CITY OF PORTLAND BUILDING PERMIT

199 WESTERN PROMENADE

PERMIT ID: 2013-00721

has permission to **Renovate 3 bathrooms & the kitchen, remove doghouse to basement on right side & add door to basement on left side, add entry porch on the right side rear - 12' x 7' & construct 21 " retaining wall & new terrace**

4 PORCH LANDING/COLUMN/ROOF EDGE
A301 SCALE: 1 1/2" = 1' - 0"

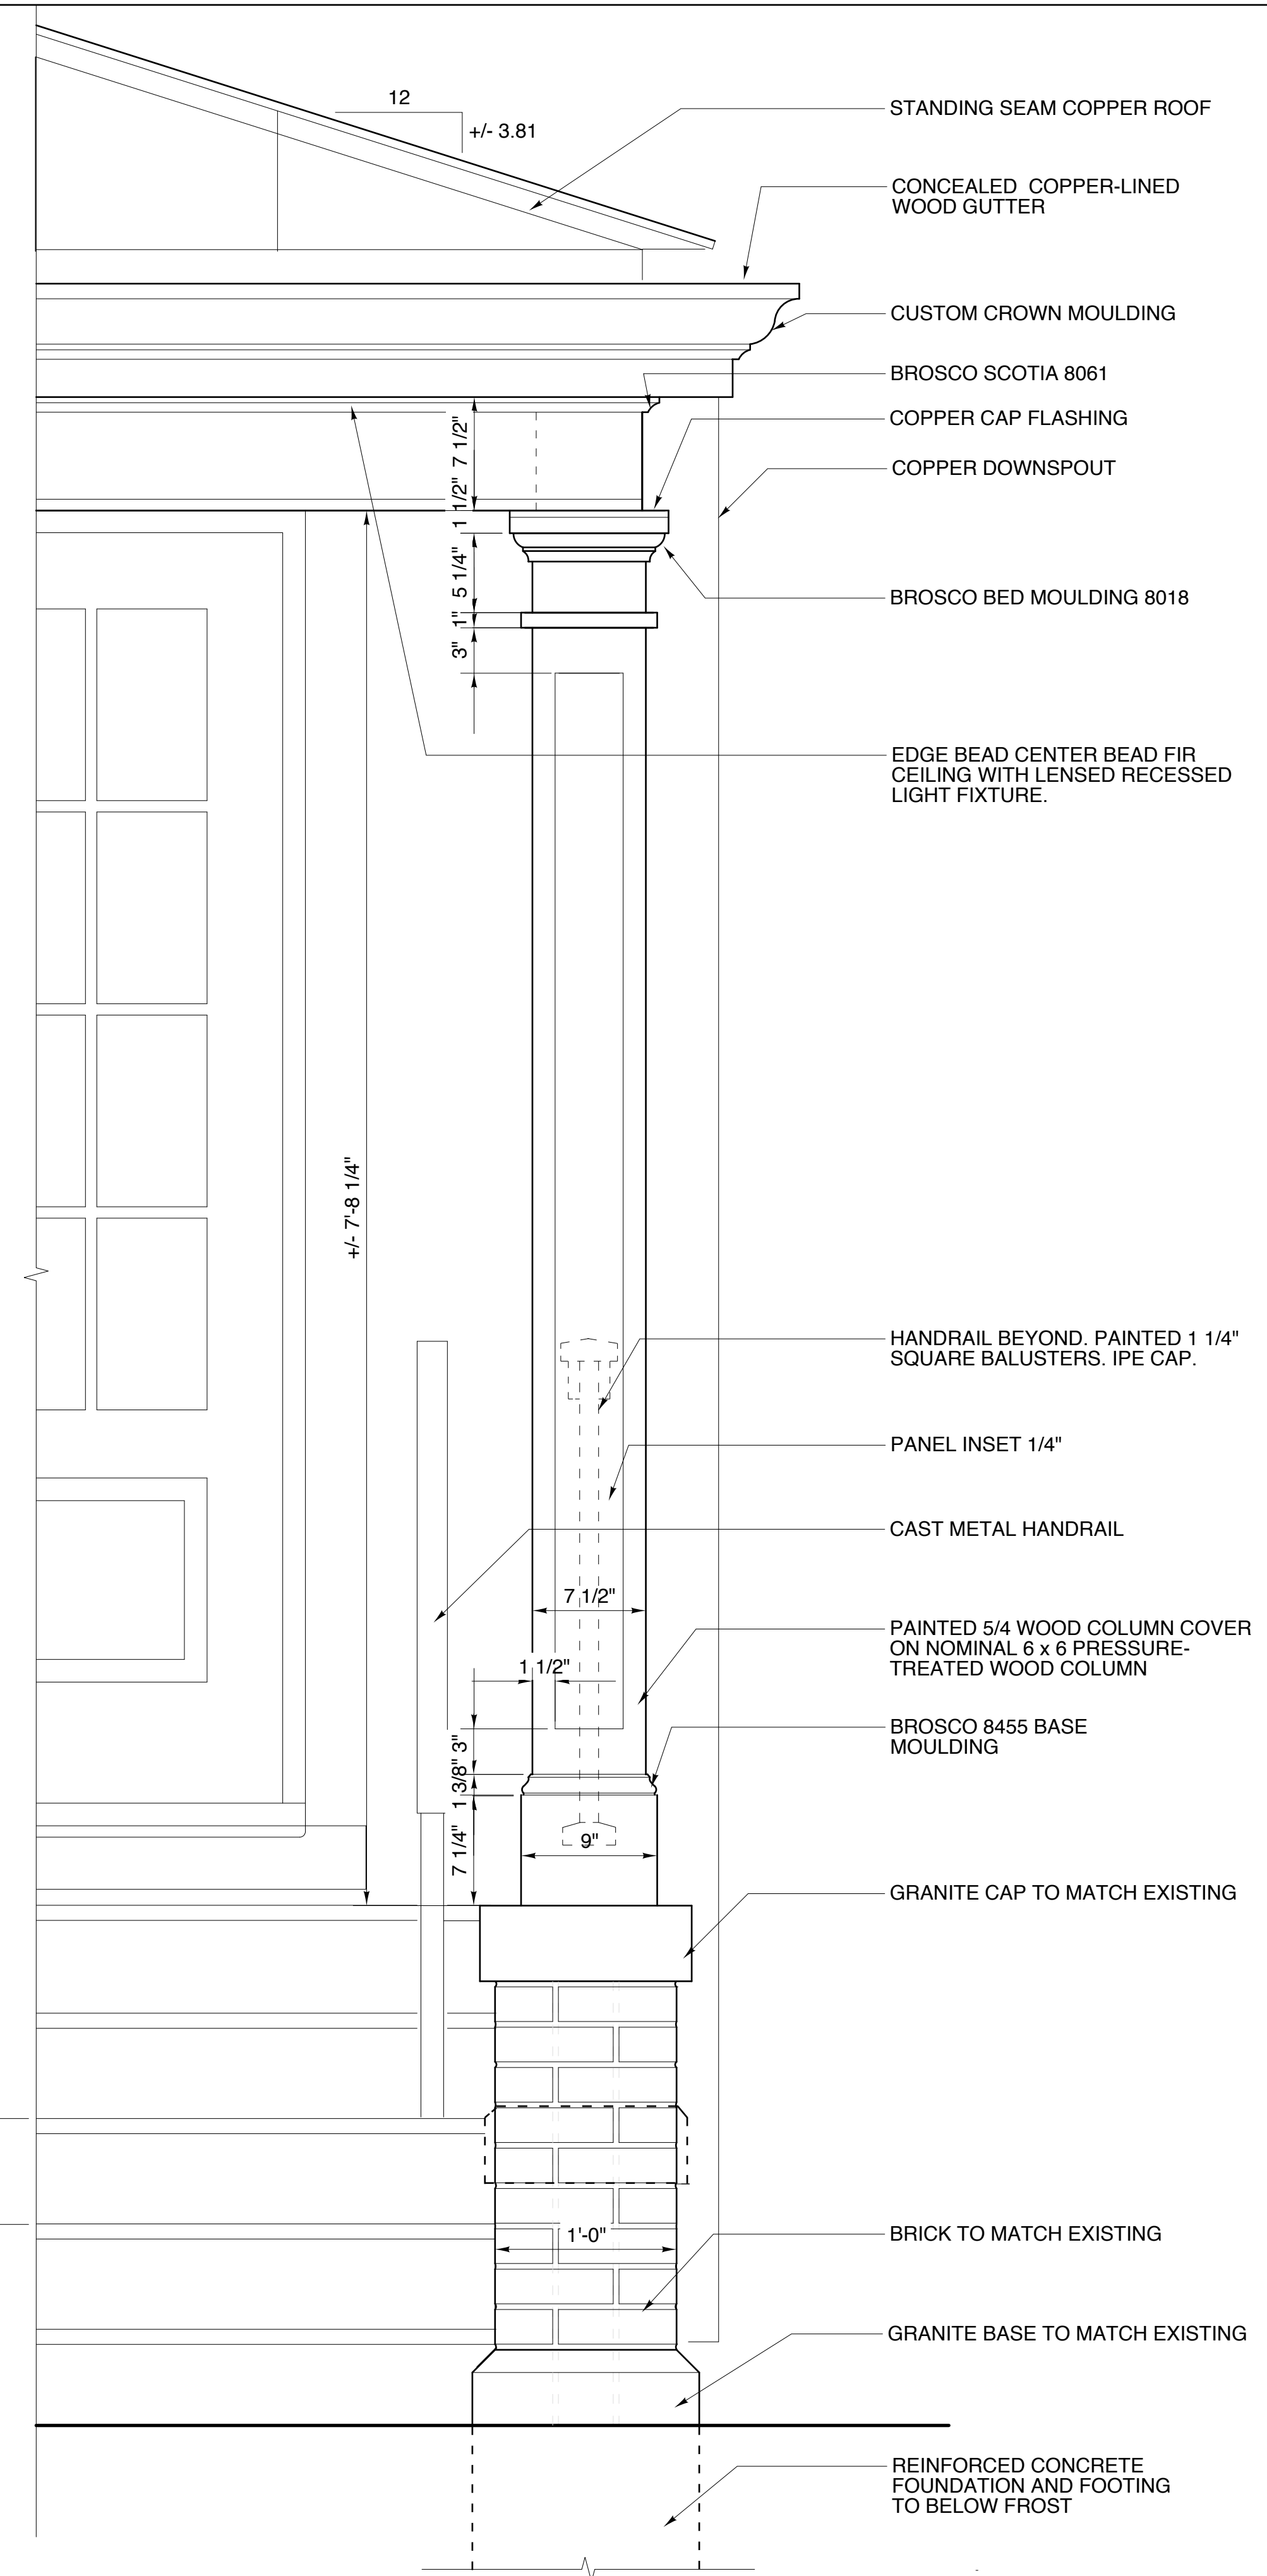
1) Any wall-mounted lighting to be reviewed and approved by staff.				
2) HP staff to review test patch of masonry prior to proceeding with any masonry work.				
Dept: Zoning	Status: Approved w/Conditions	Reviewer: Ann Machado	Approval Date: 04/30/2013	
Note: Proposed porch is not meeting the 25' rear setback. Using section 14-433. The proposed entry scales at 13'4".		Ok to Issue: <input checked="" type="checkbox"/>
